Ribble Valley Borough Council
Housing & Development Control

Your ref 3/2021/1203
Our ref D3.2021.1203
Date 3rd February 2022

Application no: **3/2021/1203**

Proposal: **Erection of a two storey rear extension with a single storey element, dormer loft conversion and associated alterations**

PROPOSED SITE PLAN
Scale 1:100

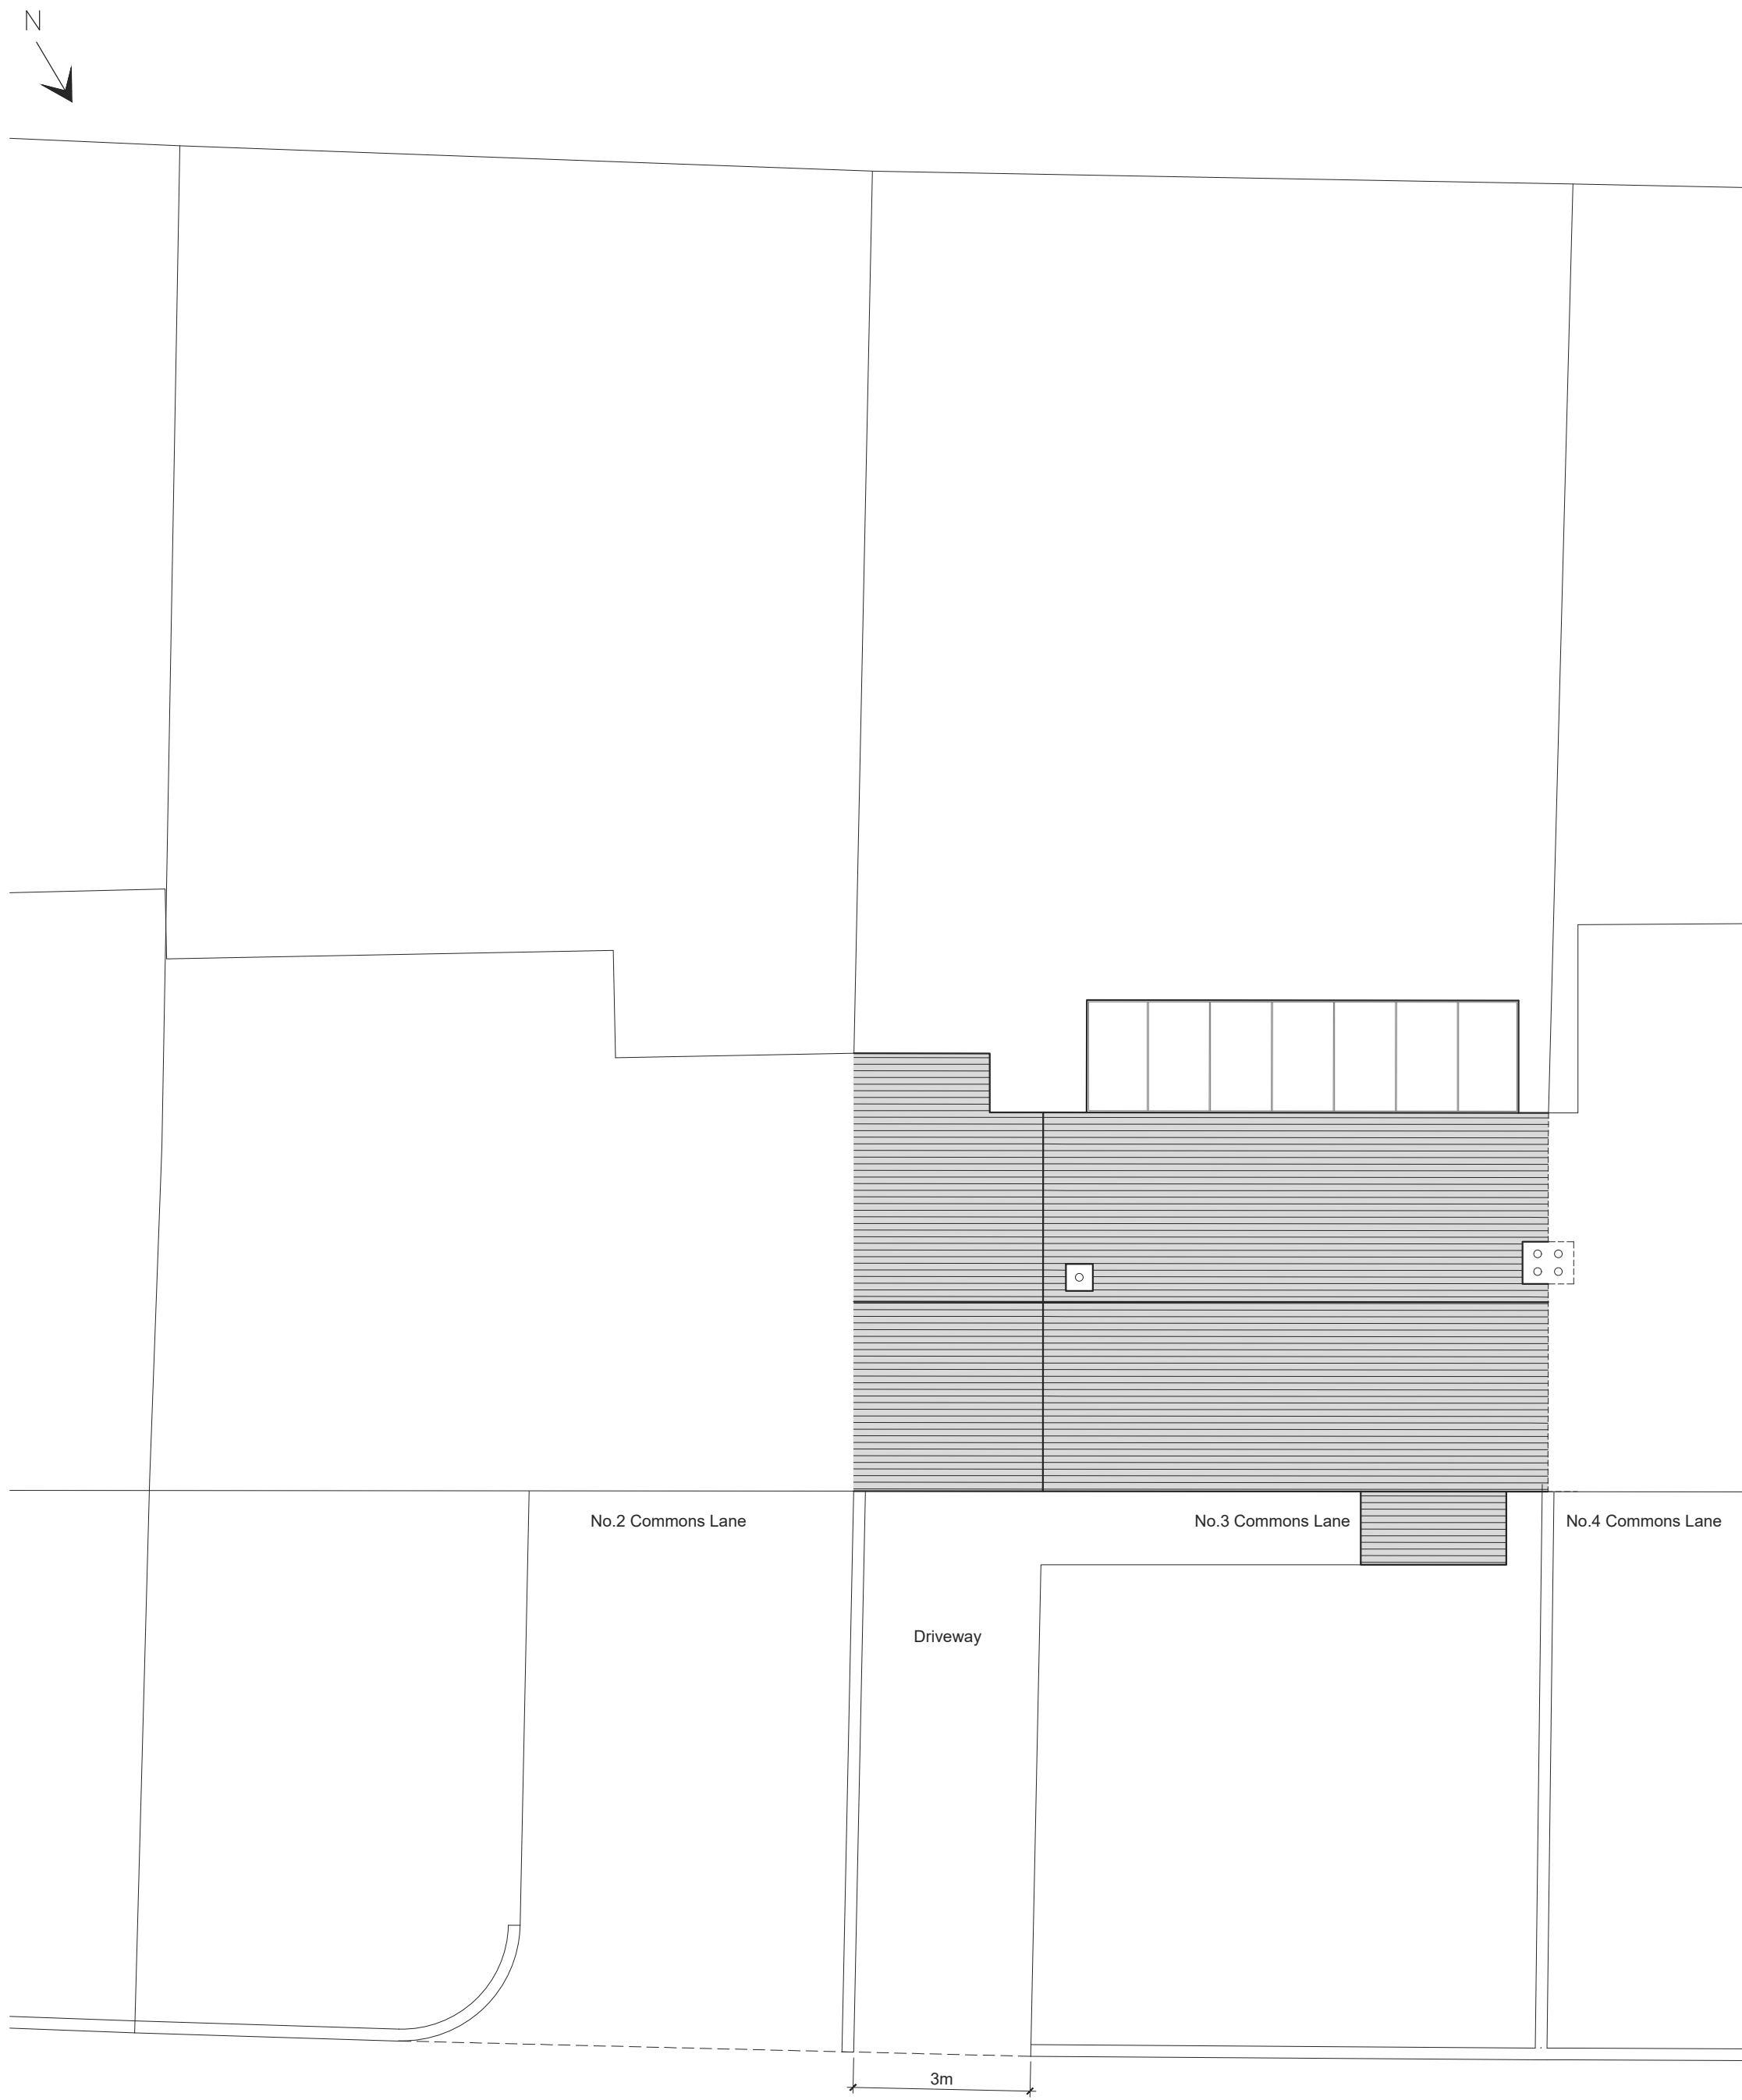
To counter this, the Applicant is proposing to extend the existing driveway as shown on RVA drawing number CL-03 titled "Existing and Proposed Site Plans." The driveway is proposing to be extended by 2.5m, making the driveway 5.5m wide. This will allow 2 car parking spaces to be provided on the driveway.

However, with the LHA viewing that the number of bedrooms at the site will increase from 3 to 4 following the loft conversion, there is a shortfall of 1 car parking space at the site.

Sometimes the LHA would accept the shortfall in parking should there being adequate space for on-street parking. However, given the narrowness of Commons Lane in this situation this is not the case. Therefore, the LHA require 3 car parking spaces to be provided on site.

As a result, the LHA advise that the driveway is further extended by another 2.5m, making the driveway 8m wide in total. This way 3 car parking spaces will be provided on the driveway. This should be shown on a revised plan and should this be forthcoming the LHA would have no objection to the proposal.
